PLANNING CONSULTATION RESPONSE

Application No	2026/0108
Proposal	Erection of 4 padel courts with a covering structure, installation of a football pitch and erection of a new associated building to include changing facilities and cafe/social areas
Address	Burntwood Sports and Leisure Centre, Common Road, Brierley, Barnsley, S72 9ET
Date of Consultation Reply	23/04/2026
Consultee	Claire Wilson, Planning Ecologist

# Appendix IV. ANNOTATED MAP OF THE SURVEY AREA POST DEVELOPMENT.

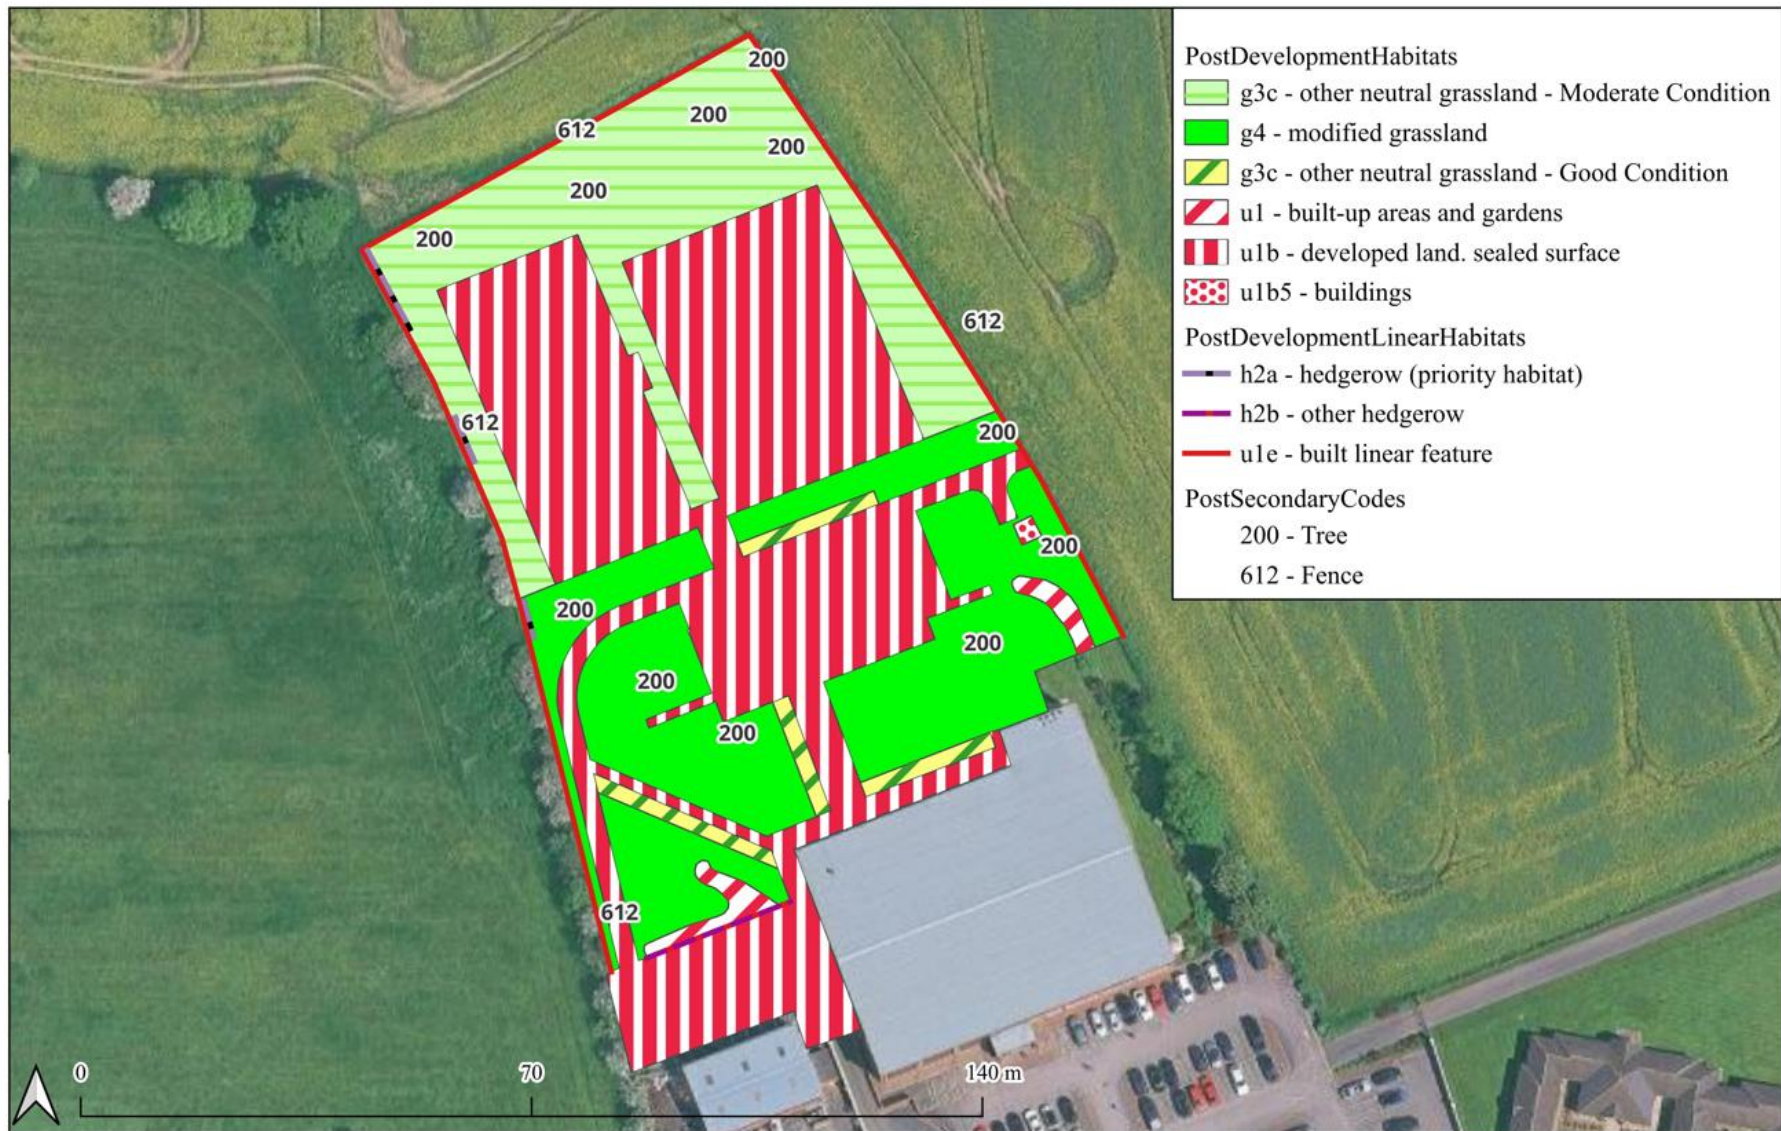
- I do not agree that it is realistic or achievable to create very small areas of good condition other neutral grassland directly adjacent to hardstanding, post development. These areas are likely to be subject to regular disturbance and are far too small in size to create a significant wildflower grassland. Modified grassland would be a more realistic habitat within these locations, as such the metric should be updated to take this into account.

- The area proposed as moderate condition other neutral grassland may be achievable, however, soil testing will be required to ensure the ground is prepared to achieve these conditions and the correct seed mix is sown.
